CITY OF ALBUQUERQUE

RE: Kairos Power

Grading and Drainage Plan Stamp Date: 9/9/20

Hydrology File: Q16DA5000A

C-100

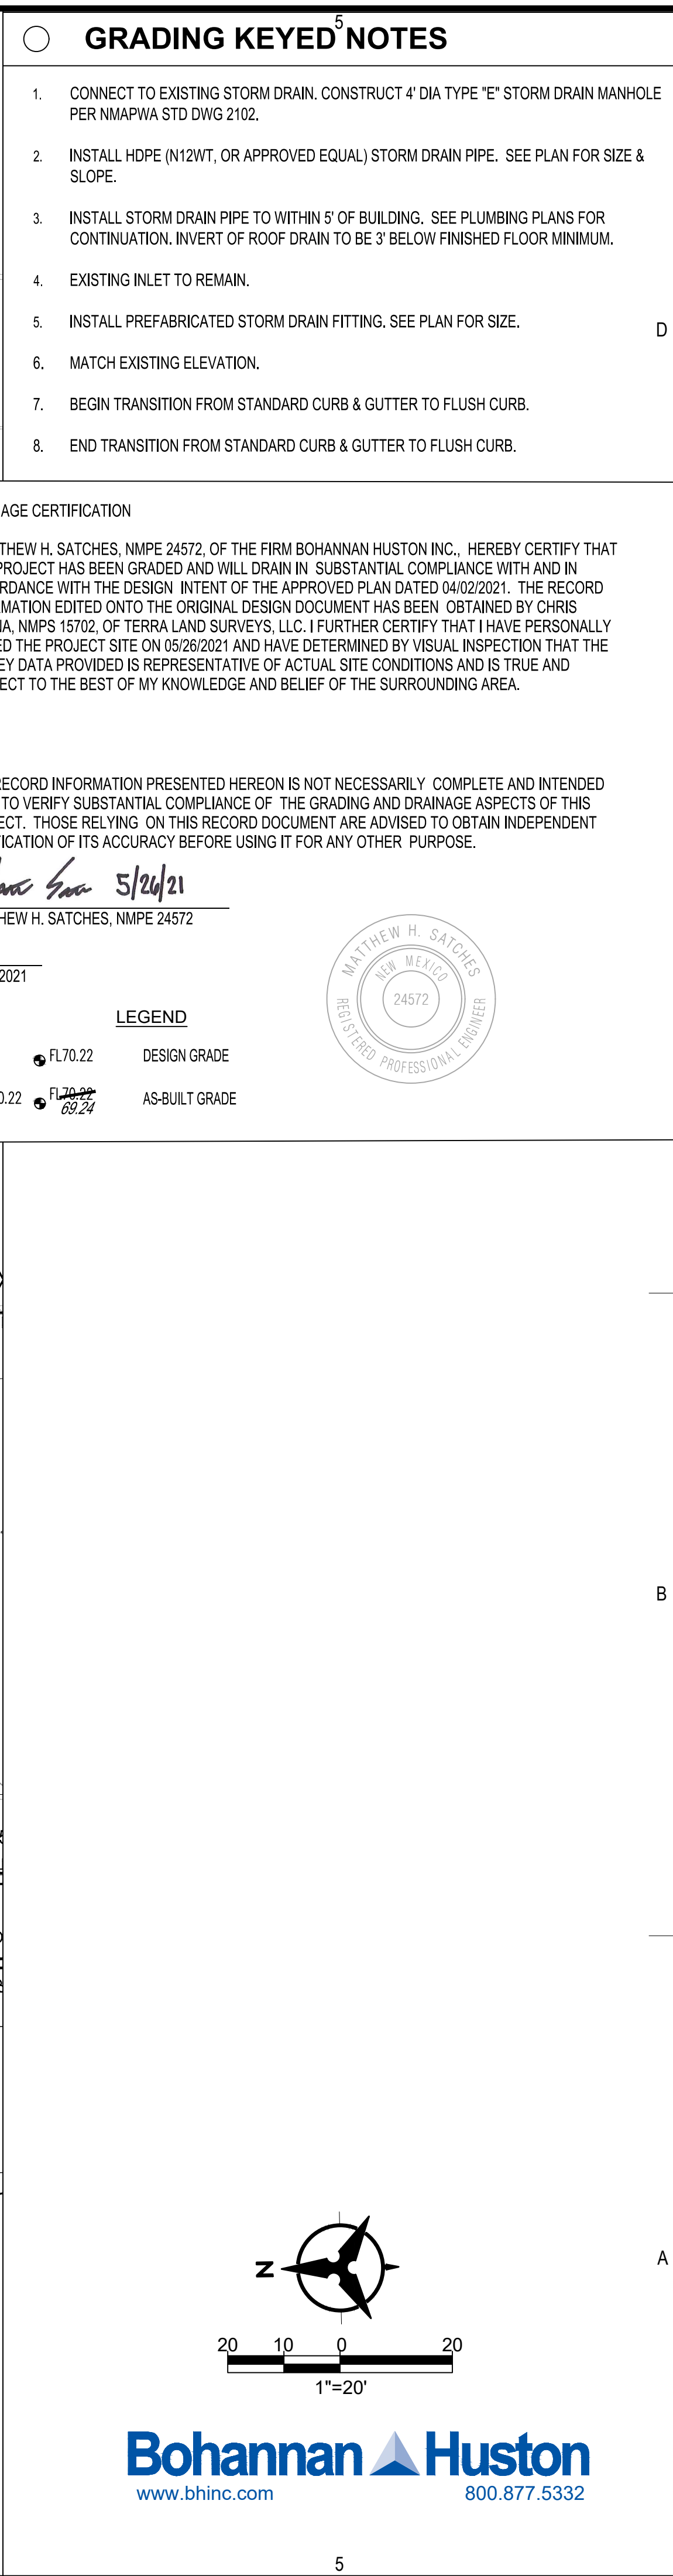
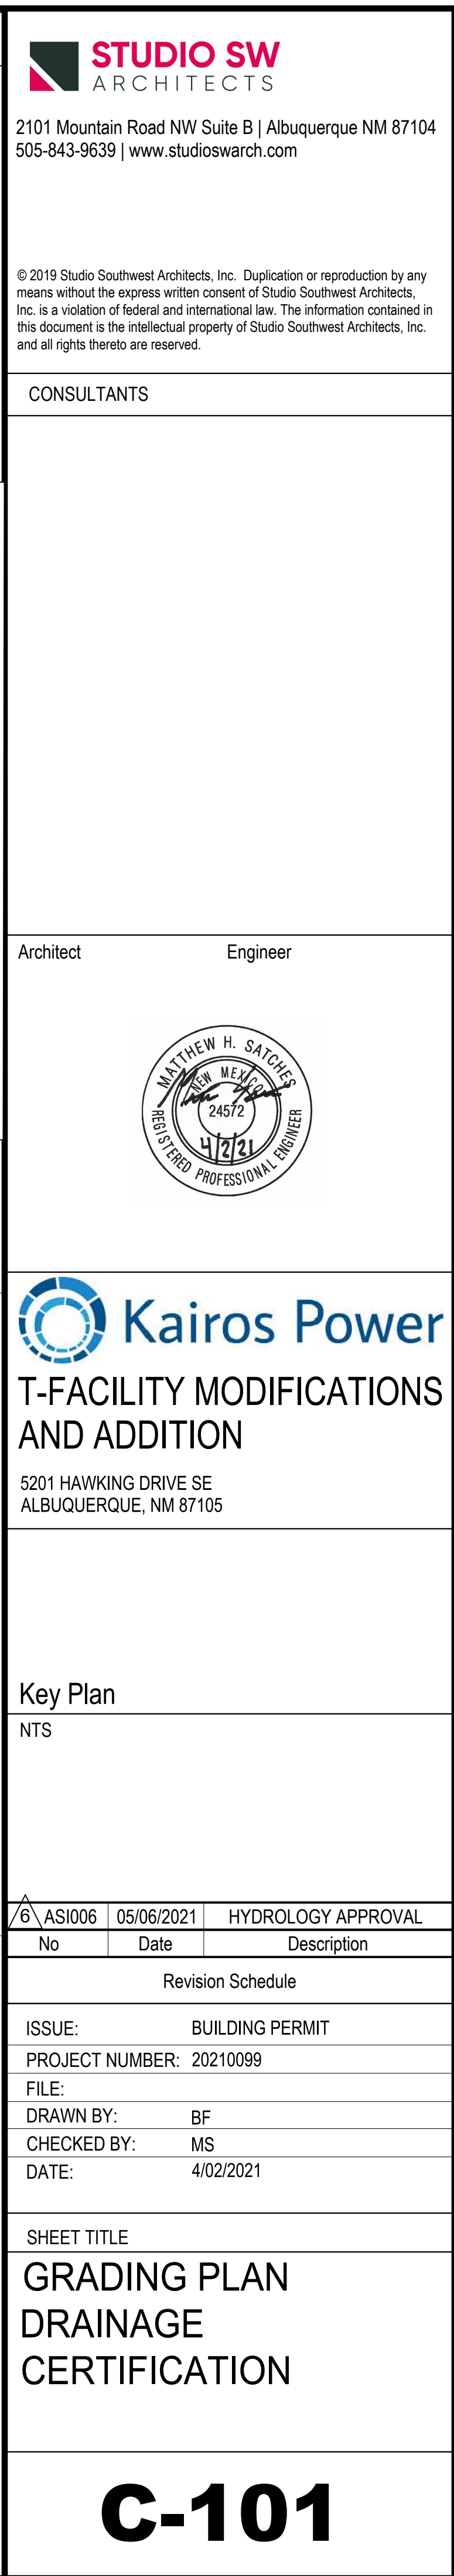
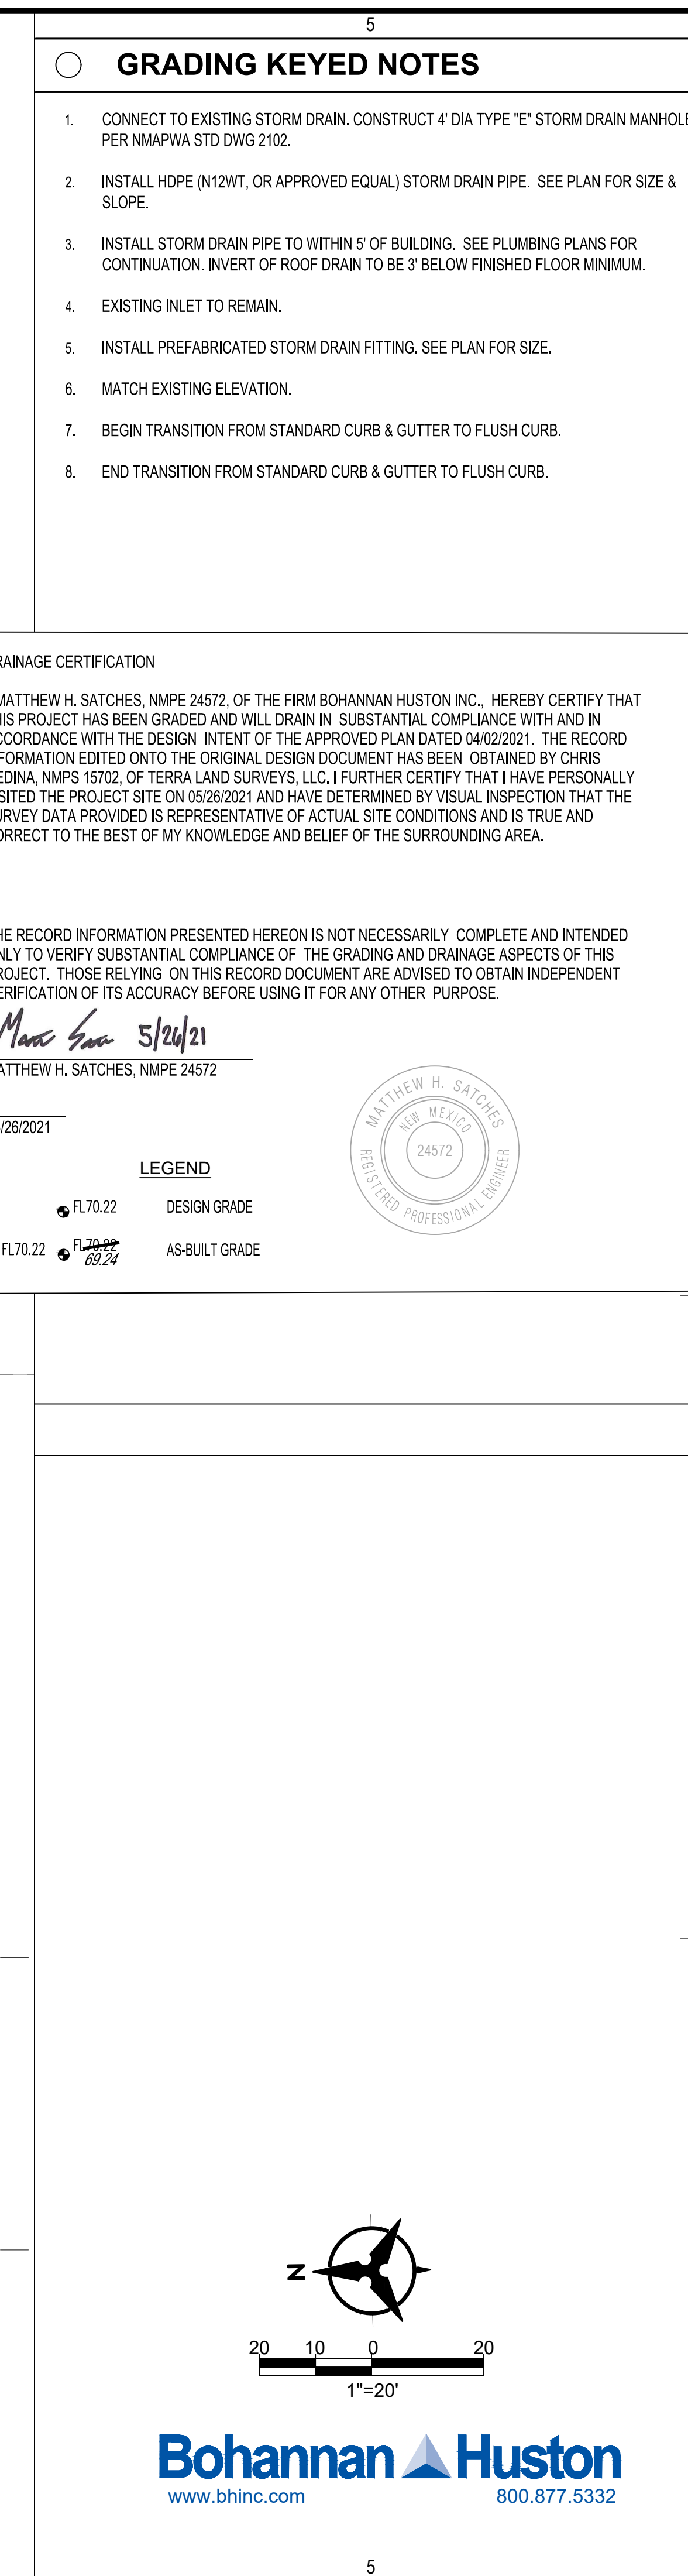
3. On sheets C-101 and C-102 keyed note 4 refers to a SD inlet, but there is no inlet called out on the plan. Is this note just part of a typical package of notes used by BHI or are there any inlets planned for this site.

Response: This has been corrected. Keyed Note 4 now references existing inlets north of the facility.

The Basin designations on your Grading Management Plan are confusing. Please consider renaming existing Basin B1 to just B so as to avoid confusion with new Basin B1, which is a sub-basin of the overall area being studied.

2. Please examine existing and proposed flow through the existing 24" SD pipe to the retention pond. I did not see this on your submittal and we need to be sure this pipe will be able to handle the proposed flows.

Response: Existing Basin Renamed "Basin A". Proposed Basins are now broken down as A1, A2, A3, etc.

Response: The existing 24" SD Pipe has a capacity of 14.77 CFS. Based on the previously approved DMP for the Schott Solar Site, approximately 8.73 CFS drains to this existing storm drain. Basins A2 and A4 contribute 5.11 CFS. The total flow of 13.84 CFS is less than the 14.77 CFS capacity based on the Manning's Equation.
